# Northumberland County Council

**Date:** 12 March 2021

## **Application by Highways England for an Order Granting Development Consent for the A1 in Northumberland – Morpeth to Ellingham**

**Deadline 4 –12 March 2021**

Representative Viewpoint No.20 View looking south from PRoW (422/020)

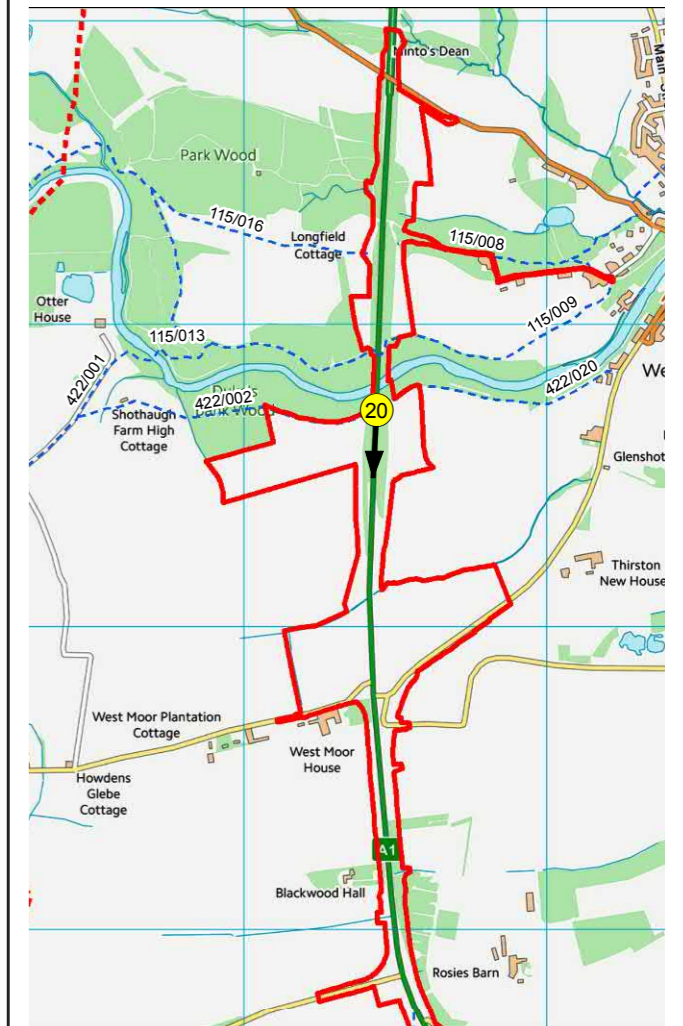
- Part A – add a visit to viewpoint 6 in between stops 1 and 2. To appreciate the presence of Coronation Avenue as a landscape feature and to view the route in its landscape setting.
- Part A – suggest walking to the point where the diversion of Public Right of Way 407/002 is proposed to the north of stop 3 to observe the suitability between the end of the detrunked section of the A1 and links to Morpeth for non-motorised transport.
- Part A – it is important to visit the west side of the A1 at stop 11 (West Moor). It may be better to find suitable parking on the west side if possible to avoid crossing the road.
- Part B – We'd suggest that the site visit to Part B starts with a drive up the B6341, with a specific note (or stop) to consider views and the landscape context from the vicinity of viewpoint 20. The remainder of the site visit could then be reversed
